A 1/17997/05

6 - 10 - 2005

Sub: CMDA - Planning Permission - Construction of

Residential/Commercial Building at P.No: 534, Kamaraj Nagar, 2nd West Street, Thiruvaniyur, Ch 41, in S.No: 39/1 part of Thiruvaniyur Village - Development charges and other charges to be remitted - Regarding.

SECTION ON AA

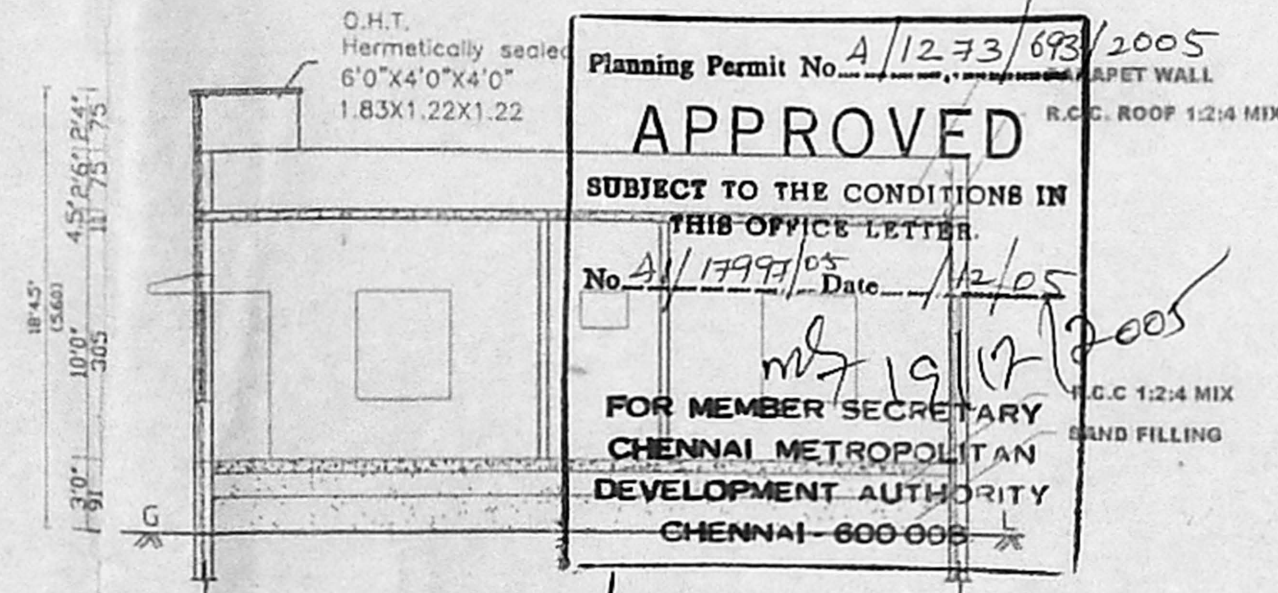
1. Demolition of existing boundary plan to be shown in a separate sheet and the same to be get approved by Council, CC.
2. R-W-H details to be shown as per standard.
3. Compound Wall details with Sec / ell by showing the gate position and 7.5 mms driveway wall along the gate to be shown.
4. Section elevation line AB should shown correctly in the G.P plan.
5. Car parking lot to be shown to scale and Septic tank details to be shown.
